TRANSPORT FOR LONDON

M25 JUNCTION 28 IMPROVEMENTS – DEADLINE 5 SUBMISSION

13 APRIL 2021

Farm Vehicle Transporter (Artic Type)	
Overall Length	15.500m
Overall Width	2.500m
Overall Body Height	2.661m
Min Body Ground Clearance	0.427m
Track Width	2.500m
Lock to Lock Time	6.00s
Kerb to Kerb Turning Radius	6.900m

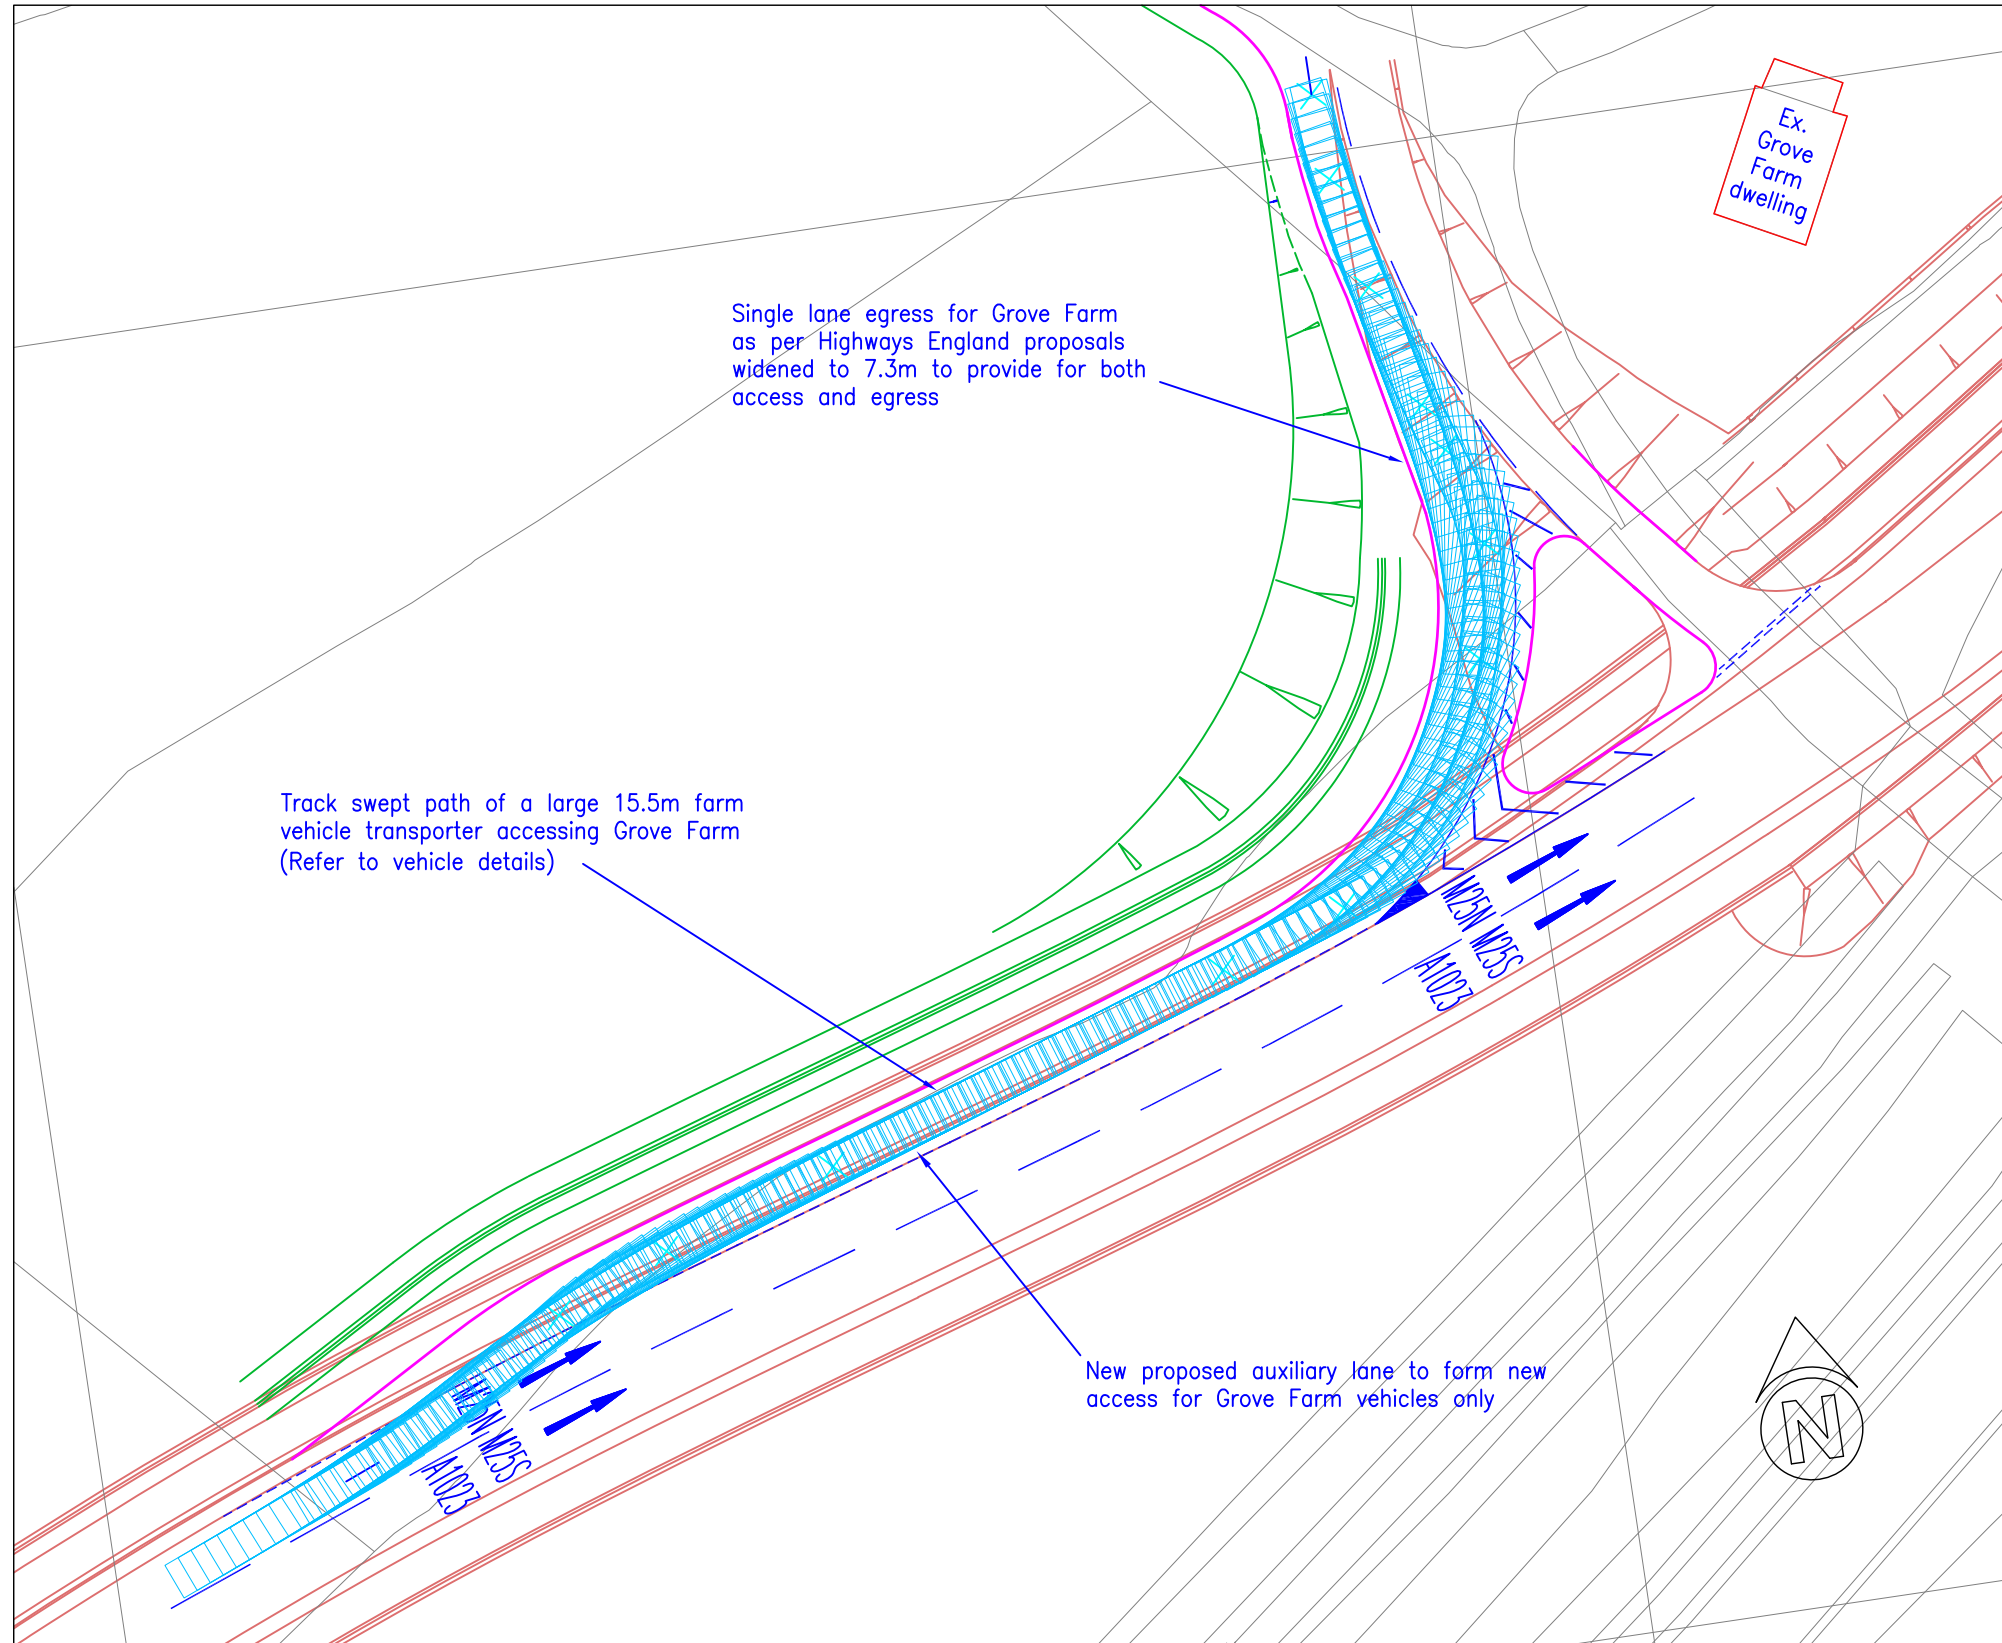
TA 2.3	<p><i>Proposed Access / Egress at Grove Farm</i></p> <p>The Applicant Transport for London London Borough of Havering</p>	<p>The representatives of Mr & Mrs Jones submitted revised proposals at Deadline 4 [REP4-036] for access / egress to and from their property.</p> <p>Provide comments on these proposals.</p>	<p>TfL has reviewed the proposed new location for the egress from Grove Farm onto the new A12 eastbound off slip road set out in the plan in document REP4-036. This results in the egress being located approximately 120 metres from the proposed stop line at the roundabout instead of the current distance of approximately 70 metres, an increase of 50 metres.</p> <p>TfL has not identified any immediate safety concerns with this proposal when compared with the layout currently proposed by the Applicant. It would be important to demonstrate that there is sufficient visibility to and from the new egress location for the required design speed. The alternative egress location may require a new or revised departure from standards.</p>

TfL is not able to comment on the proposal in terms of construction feasibility or environmental impacts and we would expect the Applicant to consider these alongside a full assessment of road safety implications.
TA 2.4	<i>Outline Traffic Management Plan</i> The Applicant Interested Parties	An outline TMP was submitted by the Applicant at Deadline 4 [REP4-013]. The ExA notes that the outline TMP does not appear to address the impact of temporary closures to the A12 eastbound off slip to junction 28 and any associated diversions during construction work. <u>For the Applicant:</u> i) Confirm that temporary closures are no longer considered necessary for this section of road. If this is not the case indicate where the diversion caused by such a closure is described in the outline TMP. <u>For Interested Parties:</u> ii) Comment on the outline TMP.	TfL's response to this question is set out in Section 4 of this document.
